Development Application and Planning Proposal Review NSW Planning Portal Concurrence and Referral

Authority	Authority's Reference	Agency Concurrence and Referral	Authority Contact	Authority Notification	Submission Due	Submission Made
NSW Dept. of Planning, Housing & Infrastructure	SSD-88953706		Sian Holmes	1/04/2026	30/04/2026	2/04/2026

Address	Land Title
Buchan Avenue, Edmondson Park	Lots 4, 5, 6, 7 & 8 DP 1275478

Environmental Impact Statement EIS for the Mixed Use Development and Rezoning at Buchan Avenue, Edmondson Park. Mixed use development including residential (shop top housing, residential flat buildings, co-living housing, affordable housing) and commercial. Concurrent rezoning including a change of zone to Mixed Use and increase in building height.

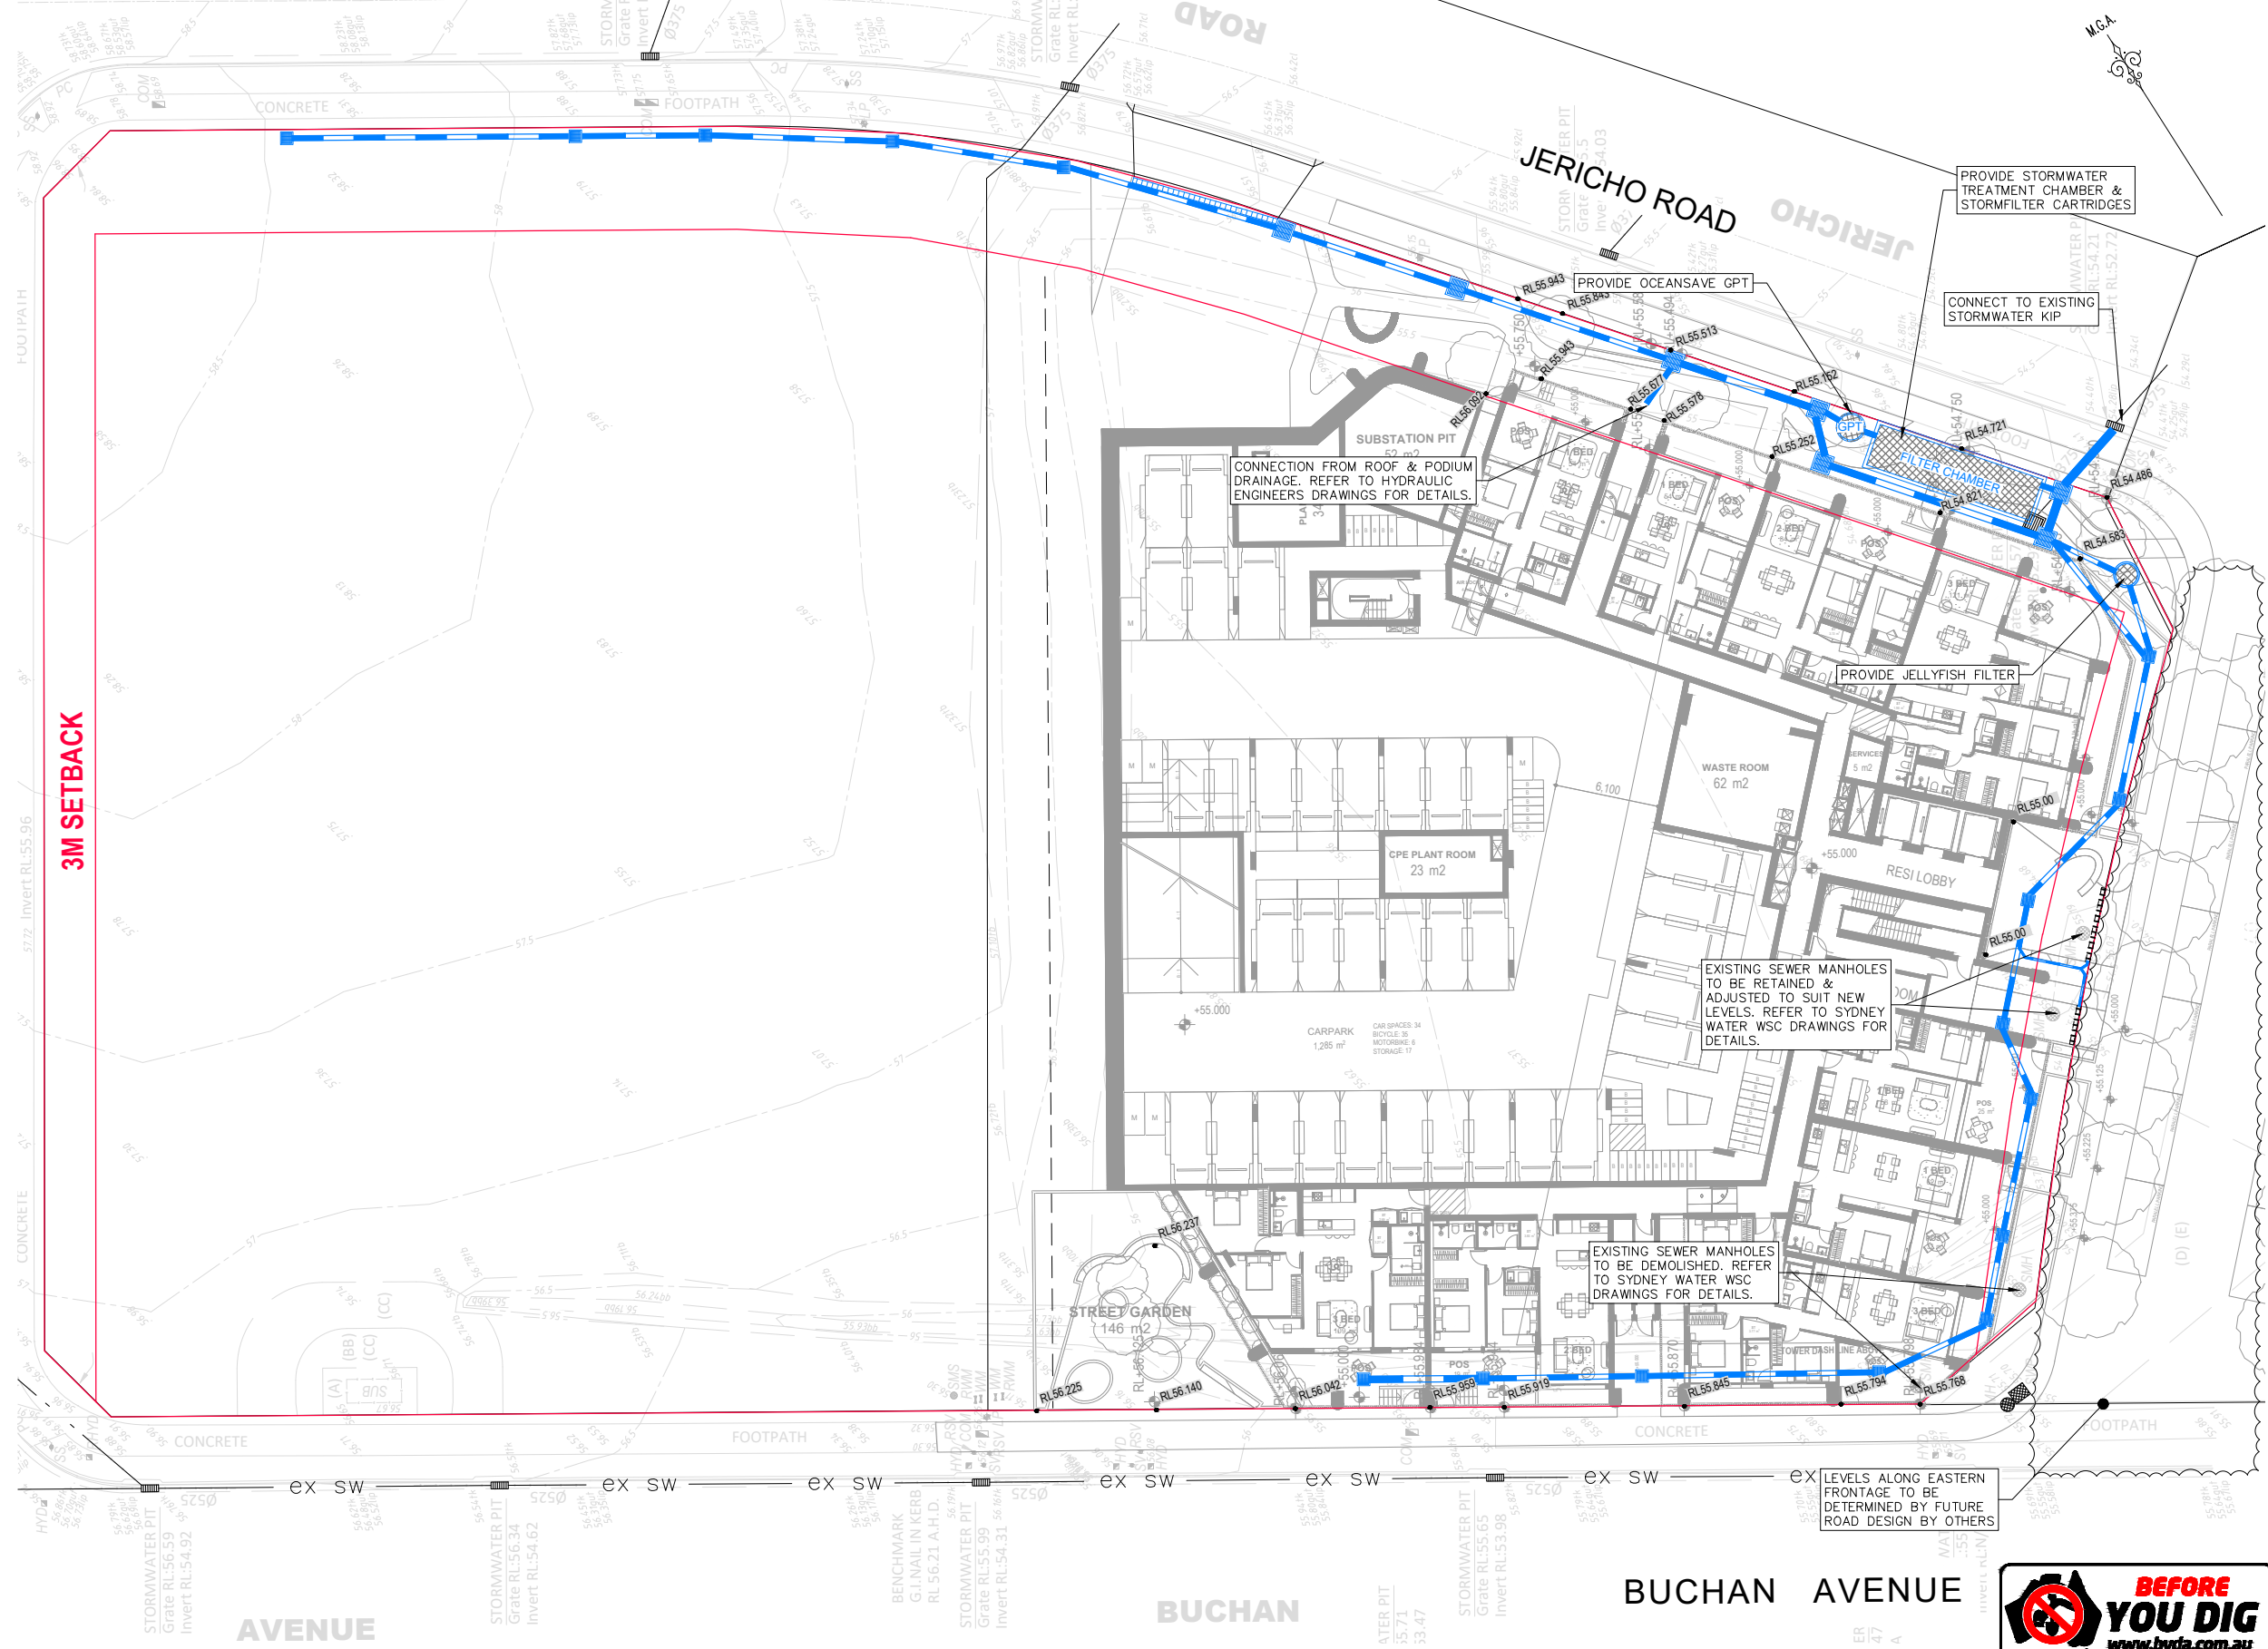
- The Environmental Impact Statement mentions but does not appear to address the easement and restrictions for fire rating and swimming pool for padmount substation no. 96063 located on the site. From the Architectural Plans it appears the padmount substation is proposed to be removed.

- For situations when network assets have to be removed or relocated to facilitate a proposed development, the applicant will need to make an application to Endeavour Energy's Customer Network Solutions Branch. The design and construction works will generally need to be funded by and arranged by the applicant under the contestable works framework by an Accredited Service Provider (ASP). However please note that this does not constitute or imply the granting of approval by Endeavour Energy to any or all of the proposed works or the associated release of easement. No easement is considered to be redundant or obsolete until it is released. Even if there is no 'Inservice' electricity distribution infrastructure, Endeavour Energy may continue to manage the easement as if network assets are in place.

- All encroachments, activities and / or works (including subdivision and even if not part of the Development Application) whether temporary or permanent within or affecting an easement, restriction, statutory right, right of access or protected works (other than those approved / certified by Endeavour Energy's Customer Network Solutions Branch as part of an enquiry / application for load or asset relocation project) need to be referred to Endeavour Energy's Easements Officers for assessment and possible approval if they meet the minimum safety requirements and controls. However please note that this does not constitute or imply the granting of approval by Endeavour Energy to any or all of the proposed encroachments and / or activities.
